Your ref:	46 Albemarle Street - Retail ...	<b>Please reply to:</b>	<b>Fraser Fikrie</b>
Our ref:	21/04764/FULL	Tel No:	0753424 7967
		Fee Queries:	0207 641 6500;
		Email:	planningreception@westminster.gov.uk;
Mr Laurence Brooker Turley 8th Floor Lacon House 84 Theobalds Road London WC1X 8NL		<b>Incomplete Applications</b> Development Planning City of Westminster PO Box 732 Redhill, RH1 9FL	
		19 July 2021

**Address: Basement And Ground Floor , 46 Albemarle Street, London, W1S 4JN**

**Proposal: Alterations to shopfront, internal alterations including the removal of internal partitions and an internal staircase from ground to basement level. (Linked with 21/04765/LBC)**

Part Elevation and Section

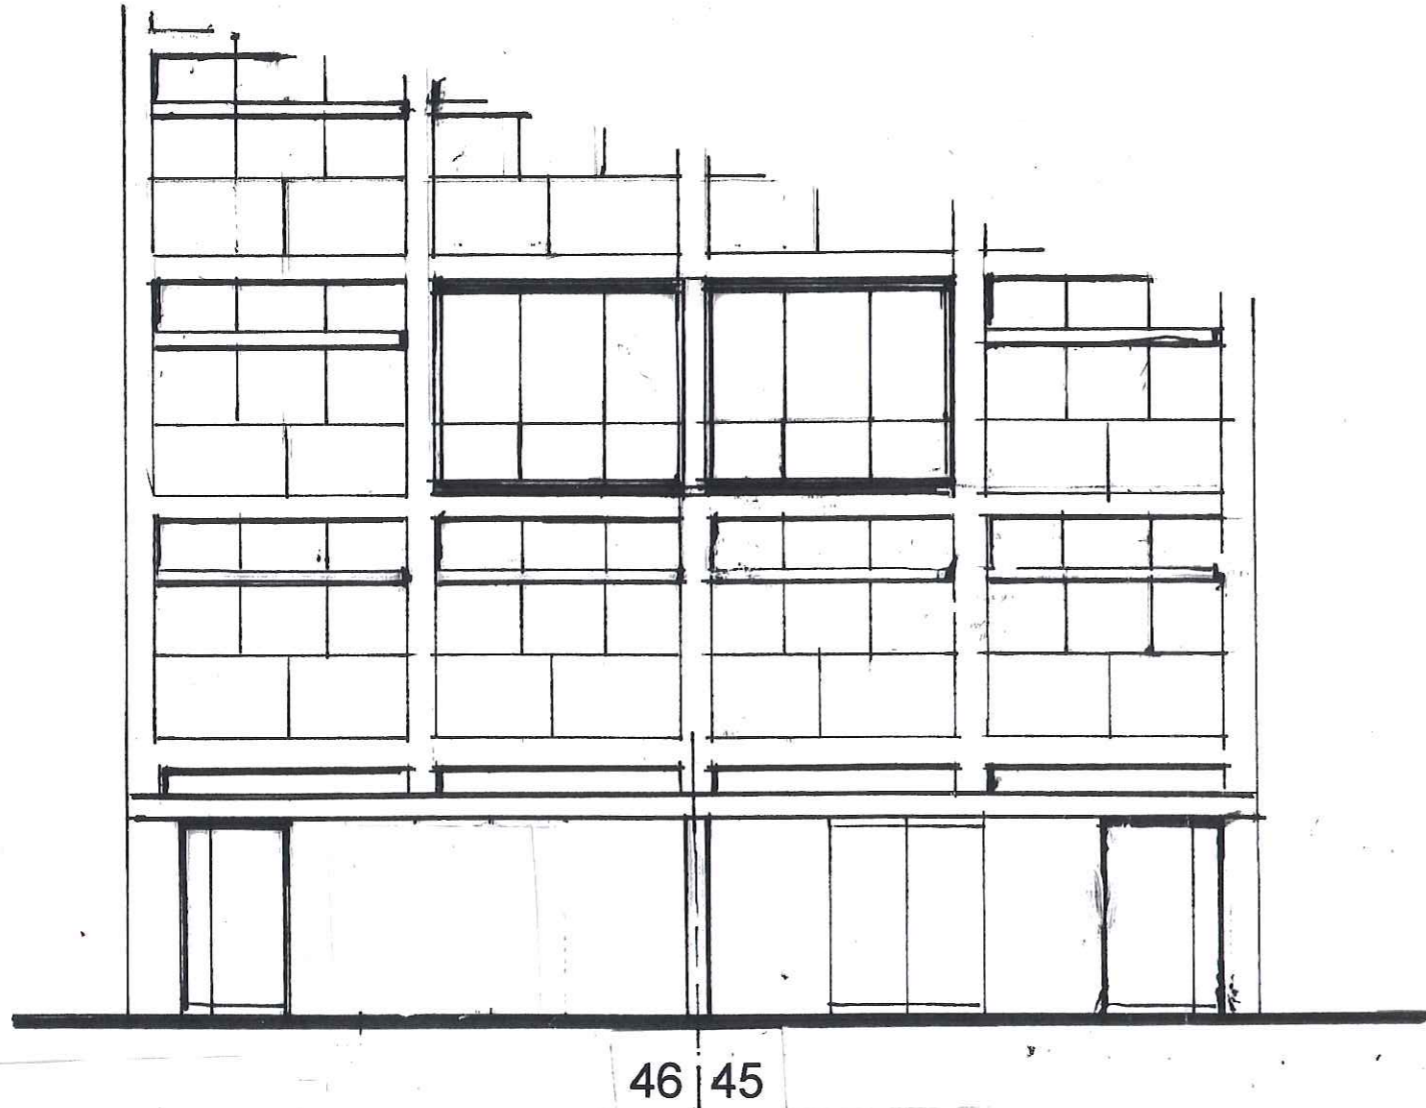
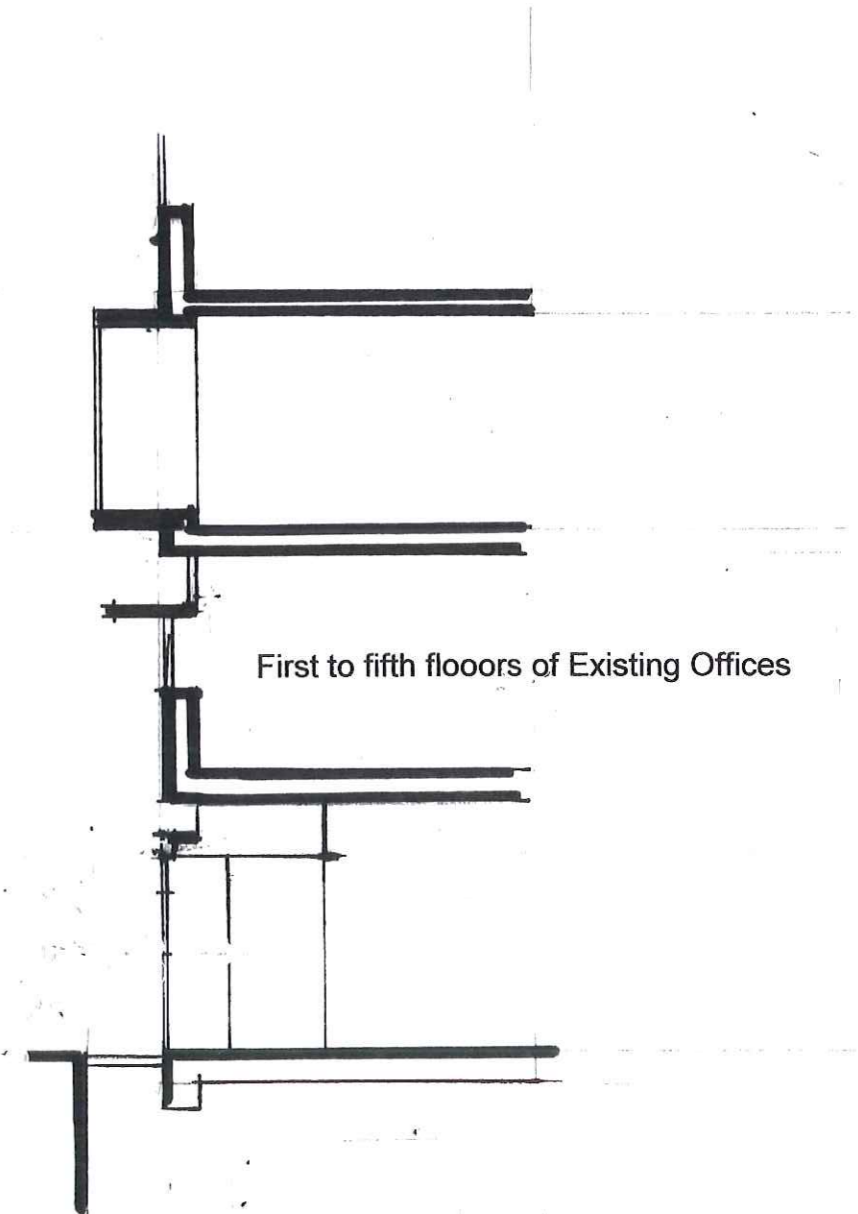
- 1 The elevation you have provided is not labelled as either existing or proposed. We require existing and proposed elevations.
  - Existing elevations with correct labelling
  - Proposed elevations with correct labelling
